TIERRA WEST, LLC

May 11, 2022

**Re: Dutch Bros NM0105
3615 Hwy 528
ESC Plan Comments**

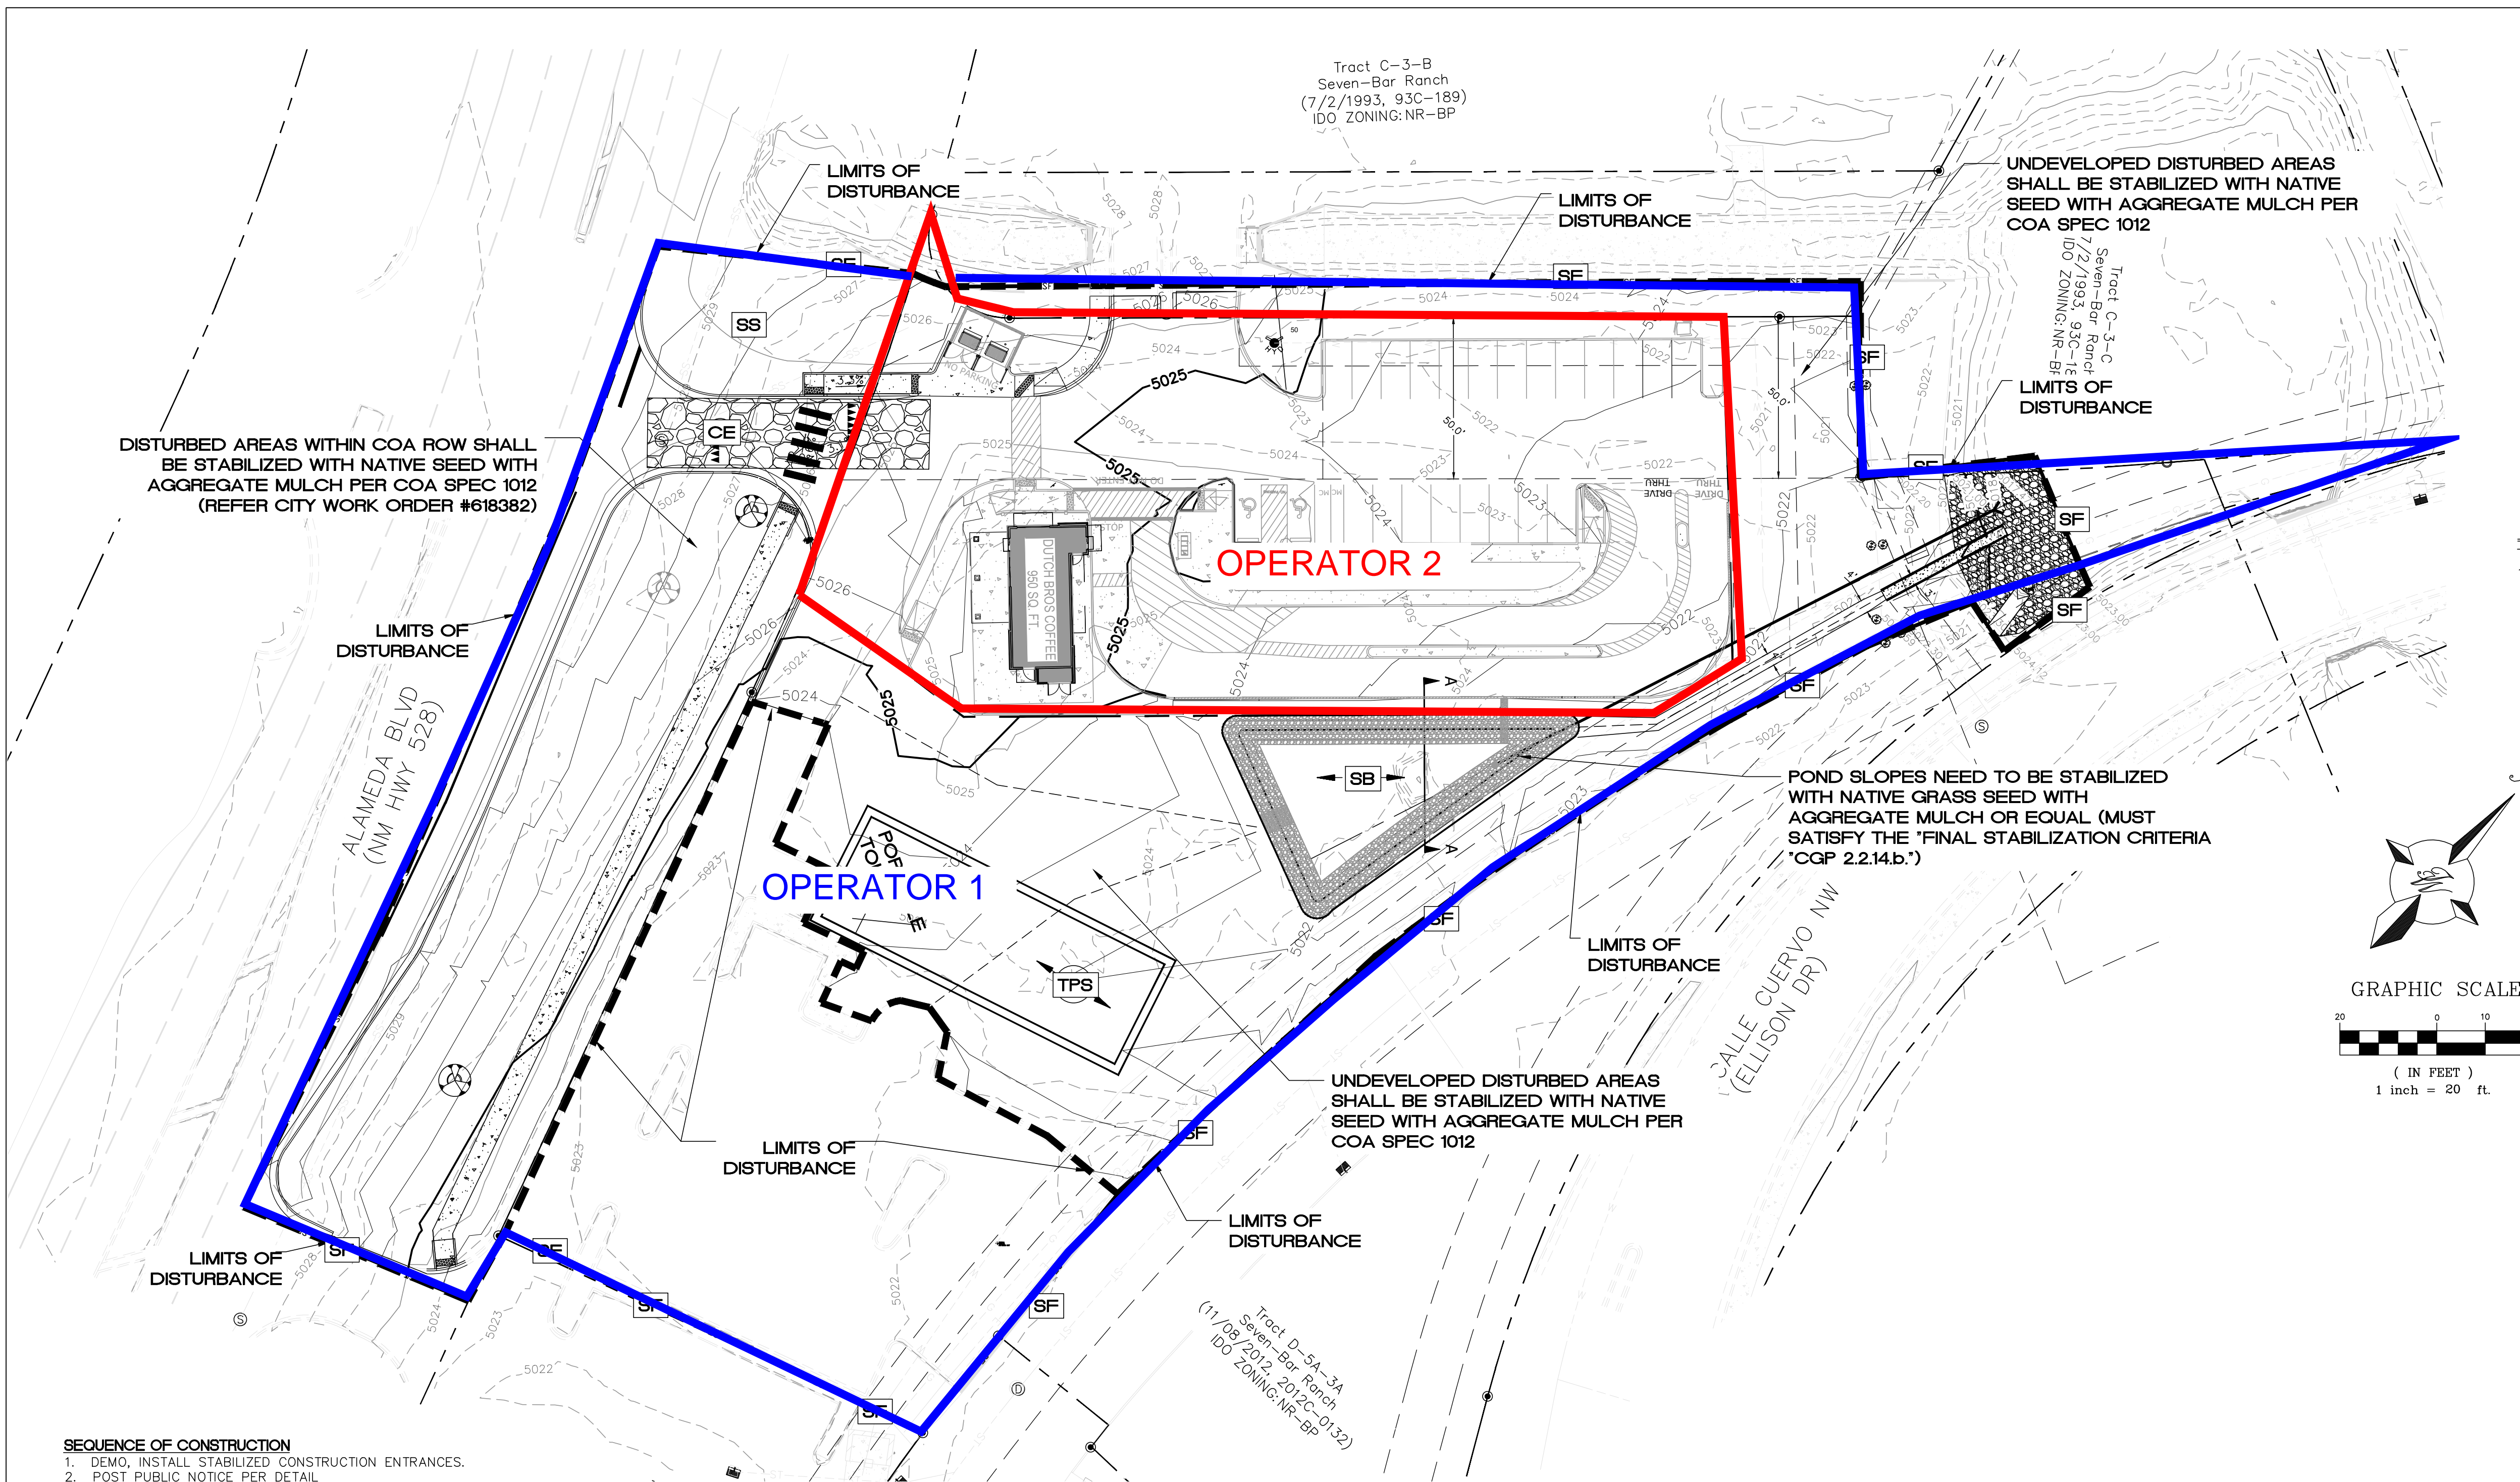
1. The limits of disturbance isn't shown. It must include all frontage improvements (CGP 7.2.4.b.i);
RESPONSE: Limits of disturbance extended to include frontage improvements.

Sheet Number:  
**LS-01**

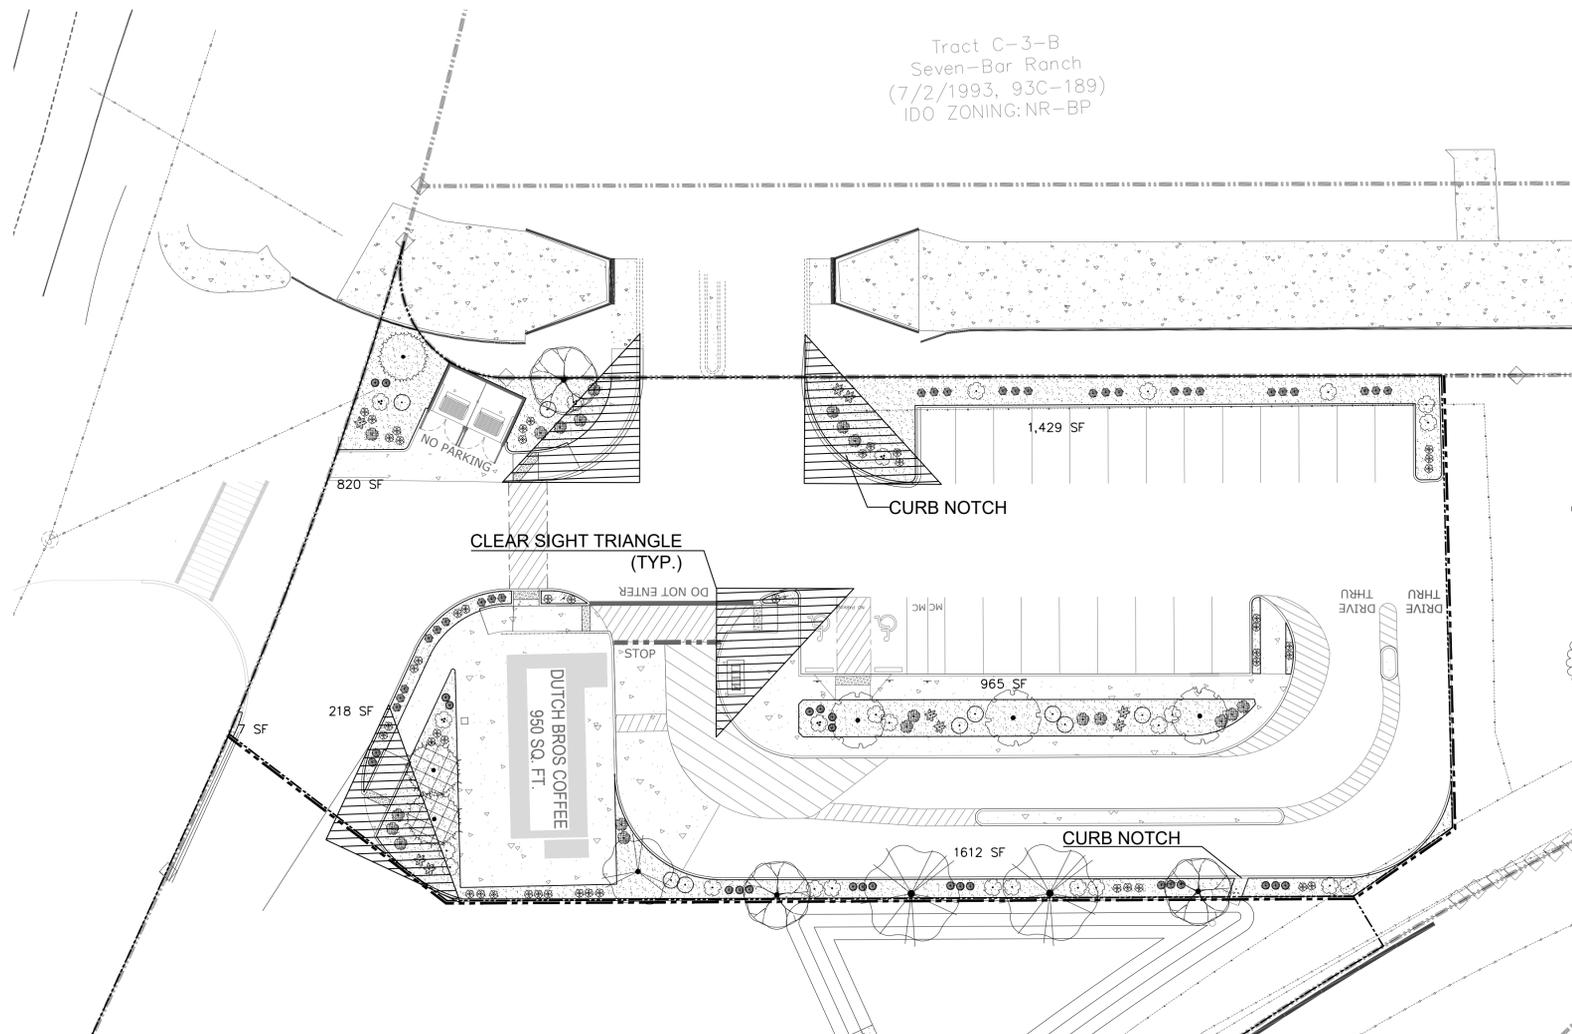
RESPONSE: Site plan attached.
3. The SWPPP must include site-specific interim and permanent stabilization per CGP 9.4.1.c.i. The Landscape Plan and Work Order sheets can be used to satisfy this requirement and should be submitted separate from the ESC Plan with the application to the Stormwater Quality Section of the Planning Department and they should be included in the SWPPP. Provide a specification on the ESC Plan for any disturbed areas not covered by the Landscape Plan or Work Order sheets.

RESPONSE: Landscape plan included as well as interim stabilization specifications called out for all areas that are to be disturbed but not landscaped or developed.

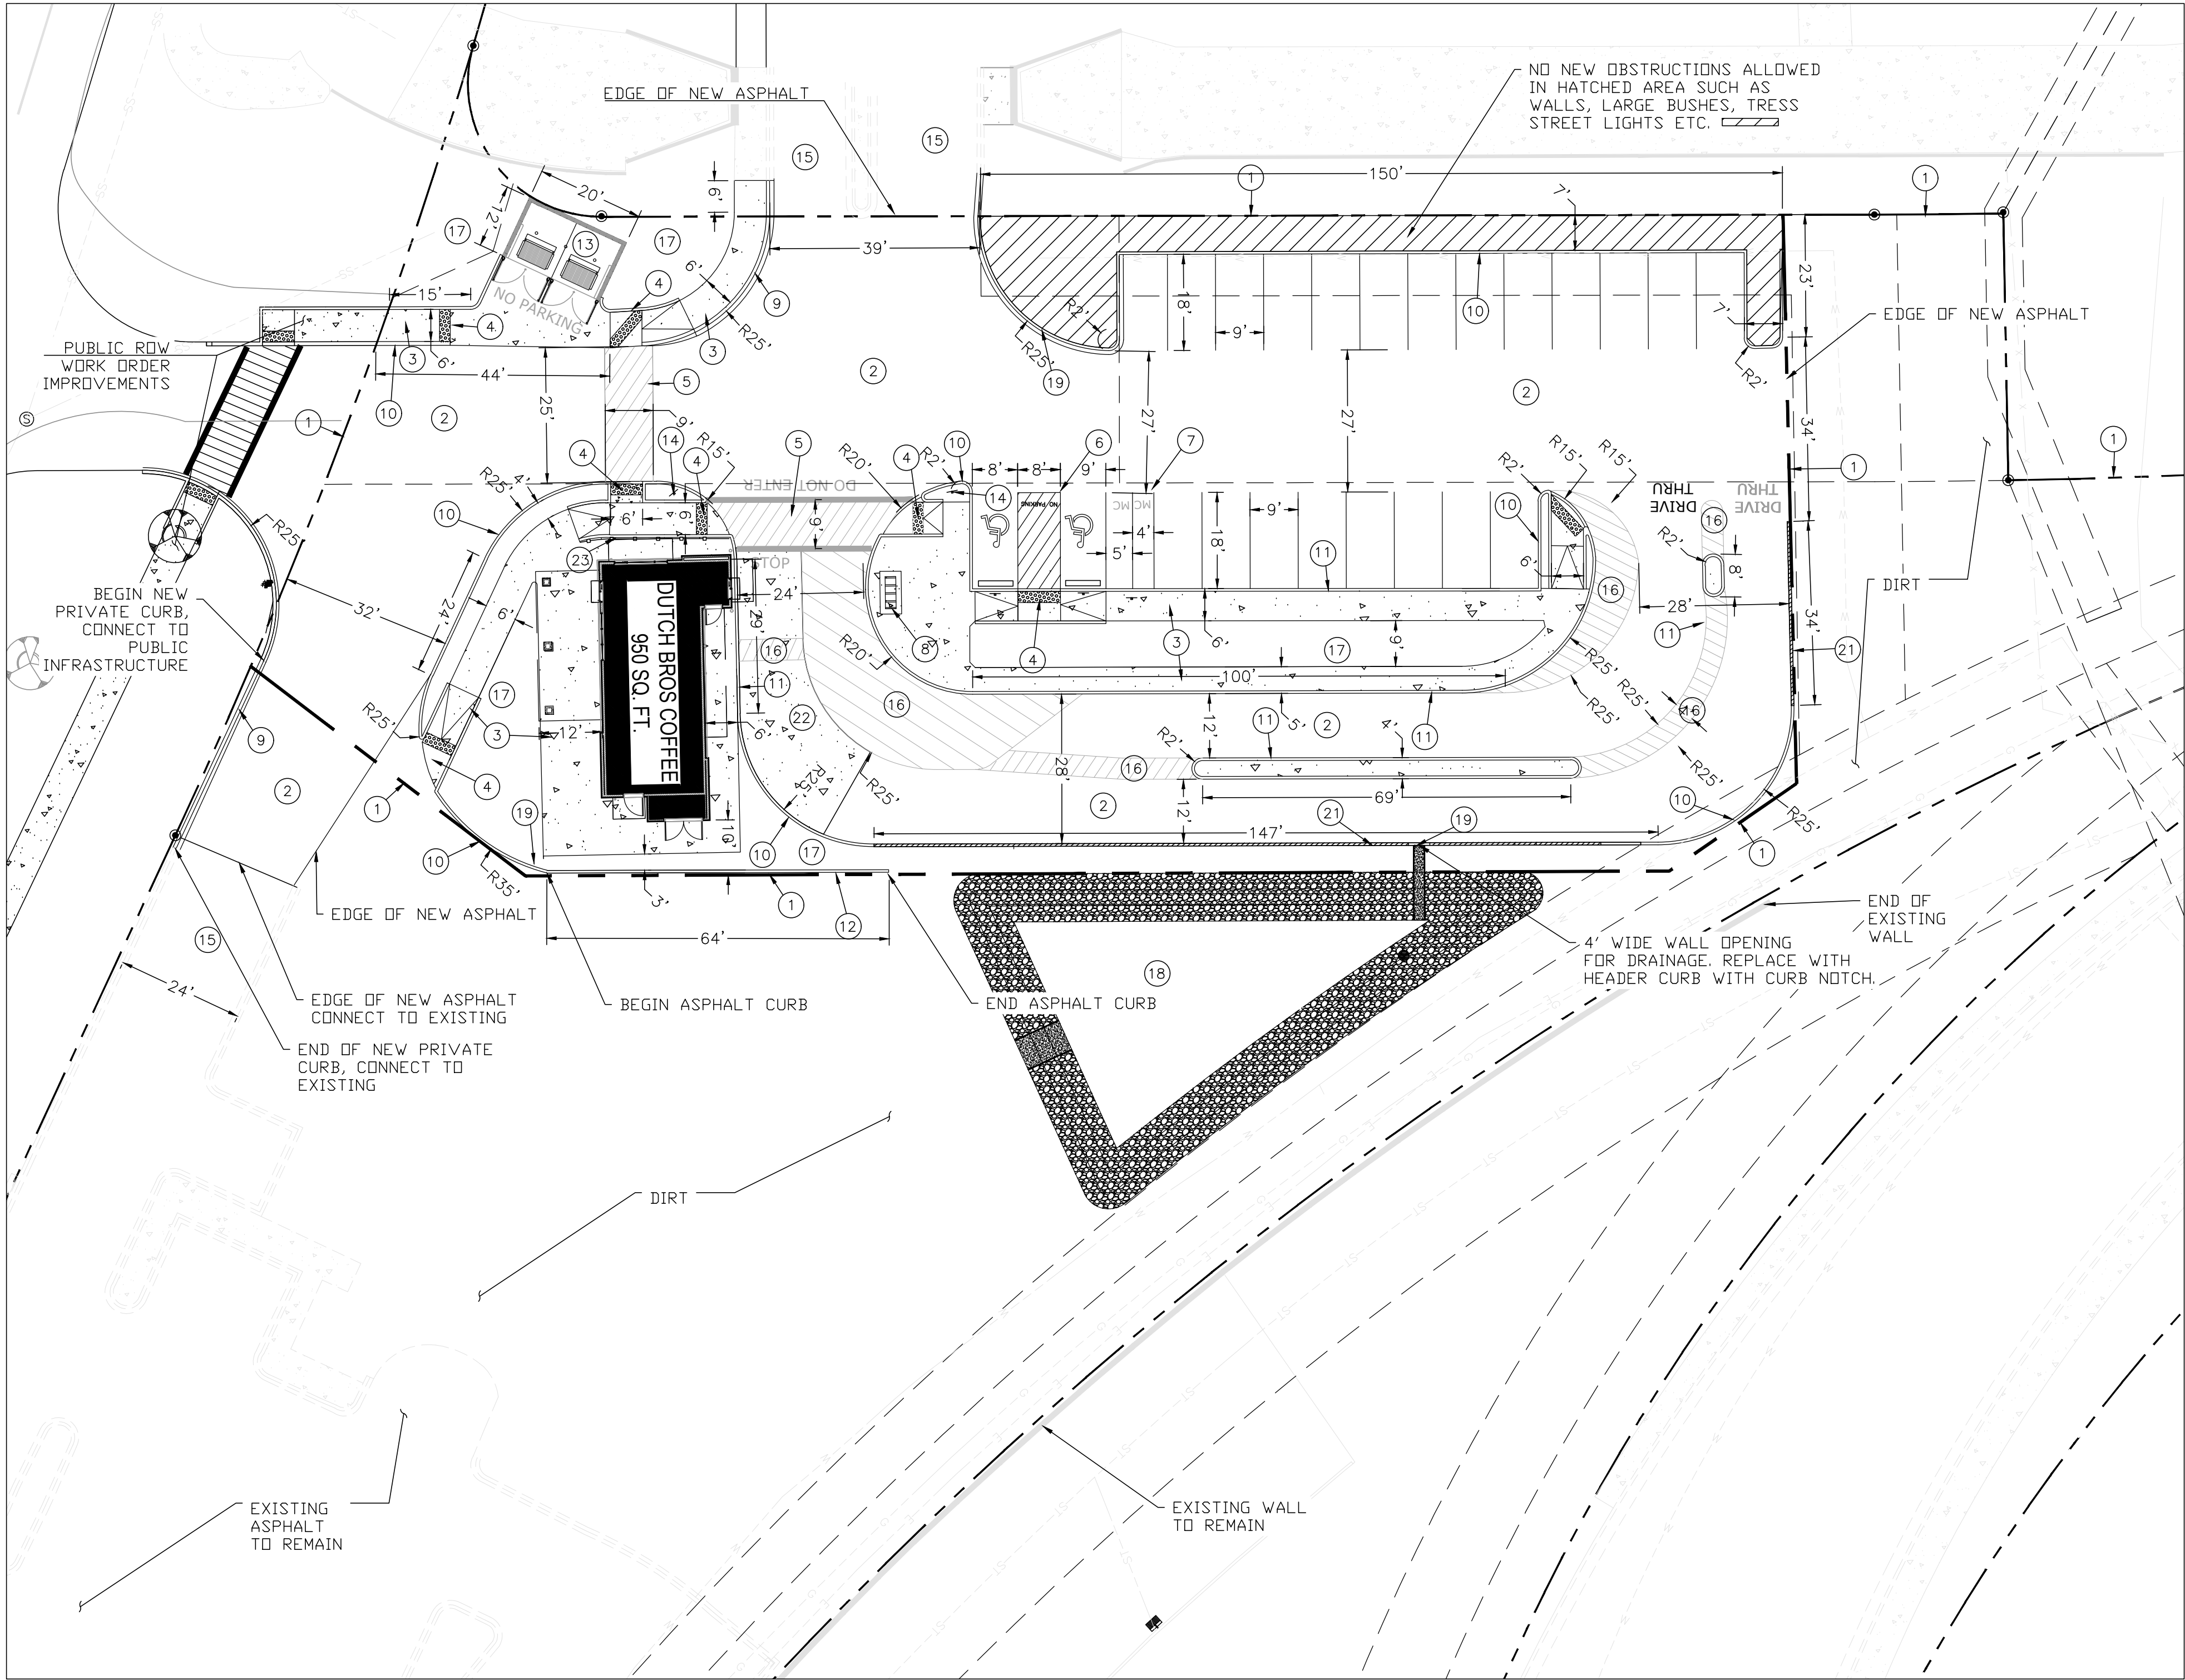
2. I can't tell the difference between building, sidewalk, asphalt, and dirt on the ESC Plan. These structures must be clearly identified in the SWPPP per CGP 7.2.4.b.vi. The same information is required in the ESC Application. You may attach a copy of the Site Plan to both the SWPPP and the ESC Application to address this requirement.
